NSW GOVERNMENT
Department of Planning

Our Ref: MP 05-0141
File No.: 9041391-1

**Re: Draft Environmental Assessment for Kioloa Beach Holiday park
MP 05-00141**

SITE PLAN - KIOOLA BEACH HOLIDAY PARK
SCALE 1:1000 ON A1 SHEET

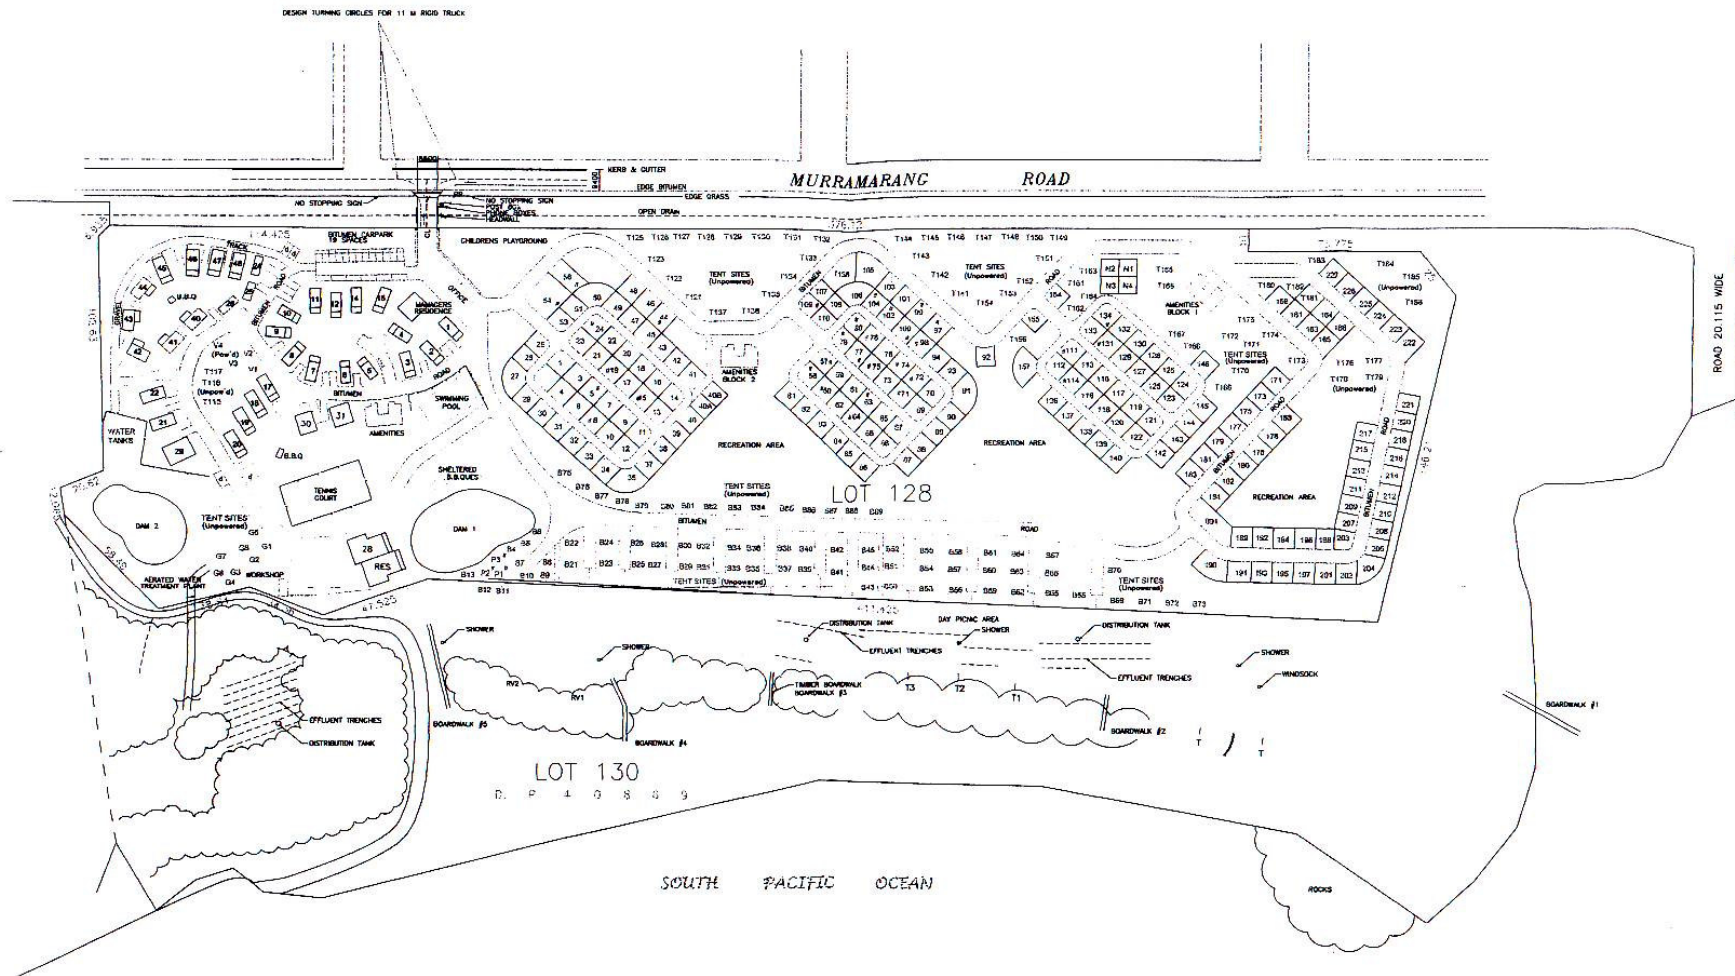
1.1 I note from a conversation of 8th May with Stephen Richardson, that the hand coloured Site Plan of the Kioloa Beach Holiday Park on file at the Department may not be a true indication of the distribution of the sites and structures on those sites. Please supply an A3 site plan which clearly indicates the camping sites, short term sites, those sites under existing consent and those for which consent is sought.
